Supporting Documents - Chartered Engineers report - Corrections to errors in the report

## SNOW LOADING TO BS6399:PART 3:1988

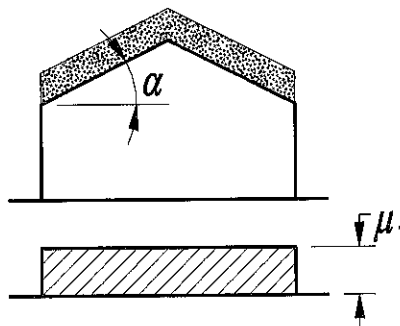
Snow loading: The location isn't Oxford and the site altitude is over 200m, not 100m. There is more likelihood of snow in a rural and high location, and especially in the windy location where the barn is situated. (Locally known as 'windy ridge'). There has been regular drifting in the location, between 1.5-2m on occasions. On one of the occasions, when we were 'snowed-in' for two weeks, I attempted to drive a quad bike through the snow to Sibford Ferris. This was via the footpath next to the barn, but I had to turn back as the snow started to come over the handlebars and it was getting deeper. This was literally only a few metres past the proposed site.

EXISTING – floor plan and elevations

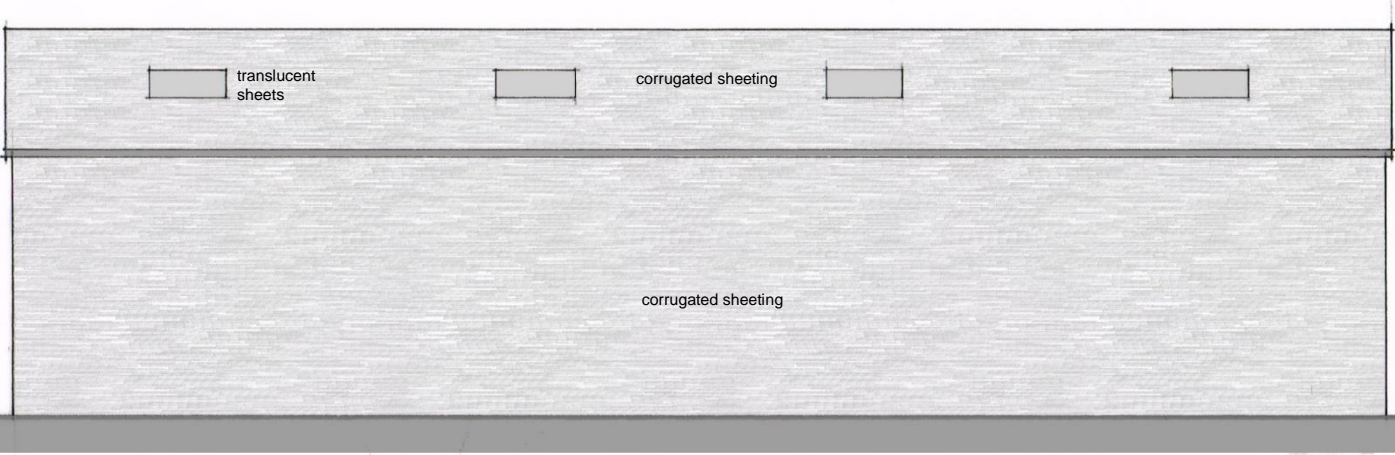
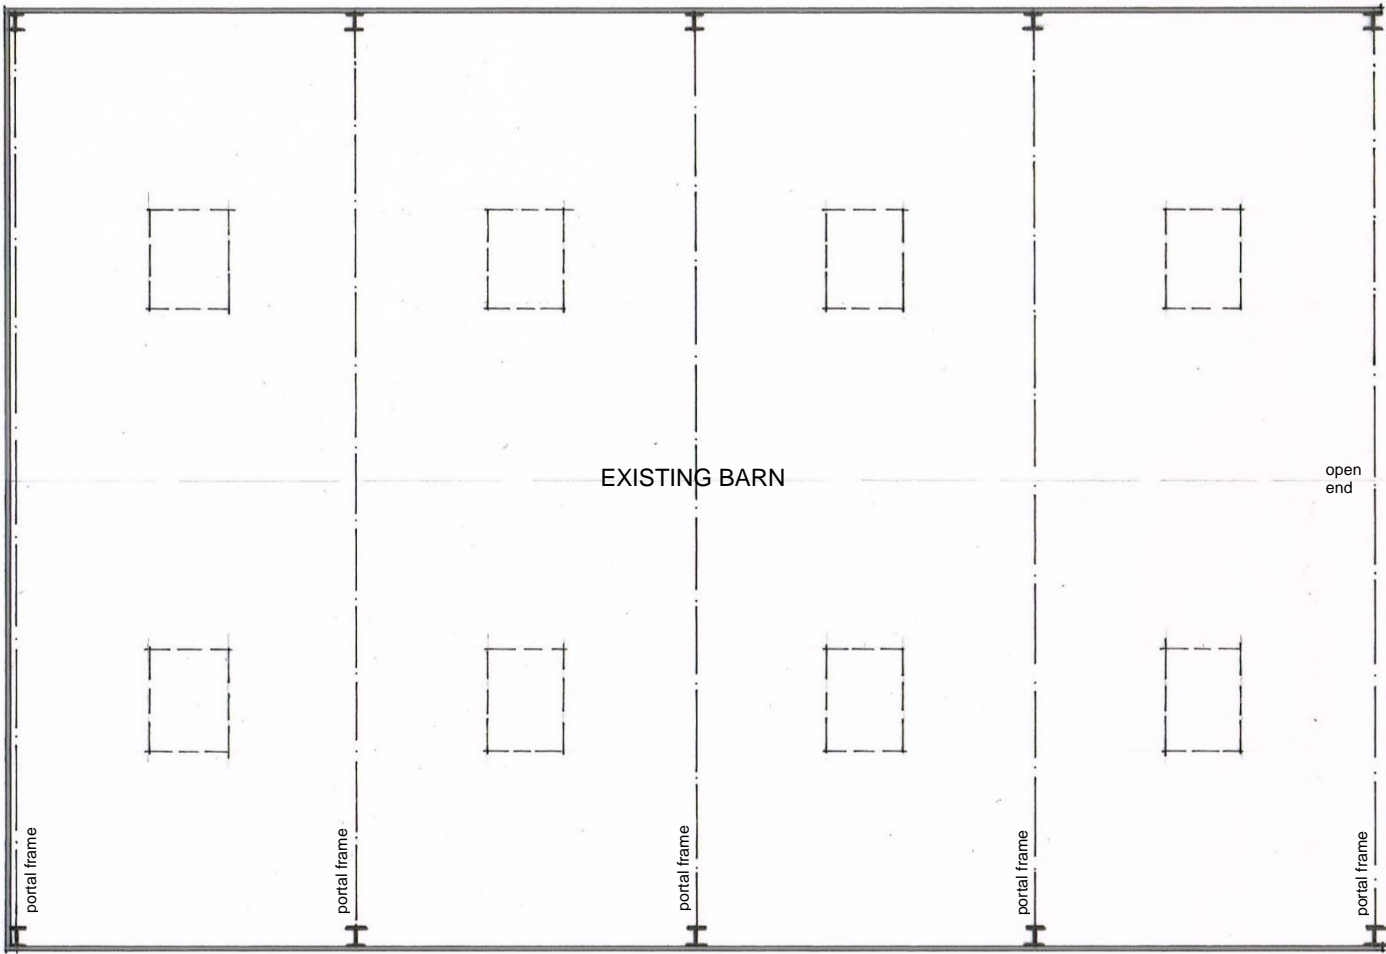
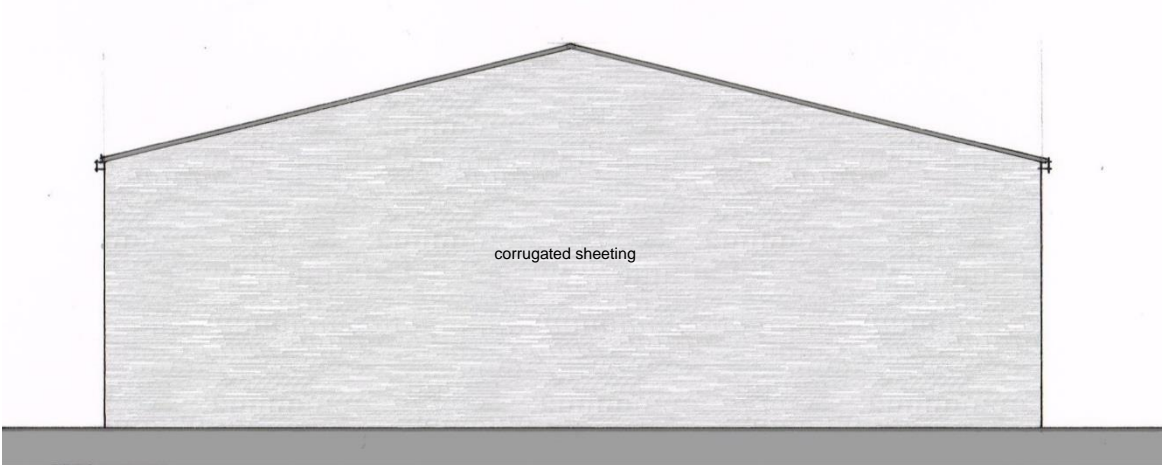
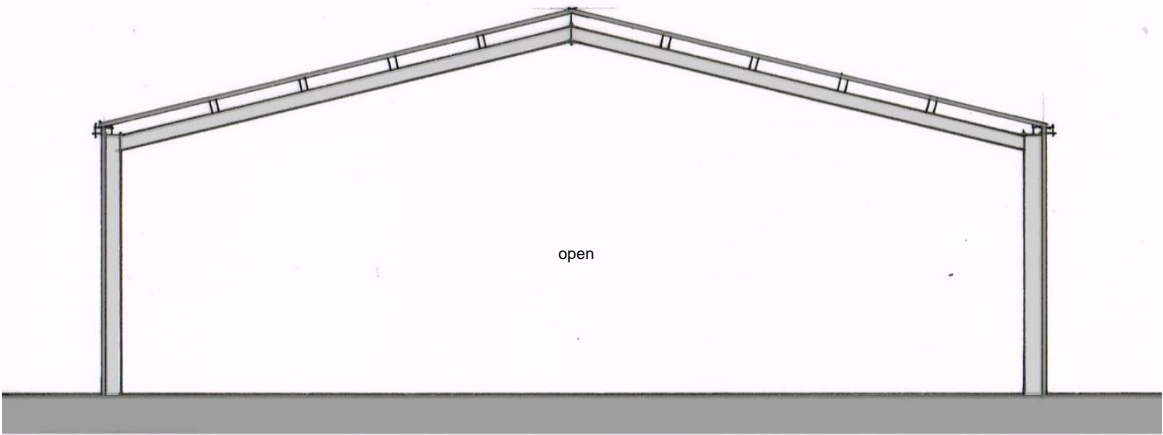
The building is not clad on all faces. The eastern side has always been open and never had 'sliding doors'. The structure is exactly the same as it stands today as to when it was constructed.

The structure isn't being retained, only the steel portal frames. The various new windows & doors will need to be put into new walls, with a new roof. At a minimum, the eastern elevation will need new foundations and the same potentially for the other three walls.
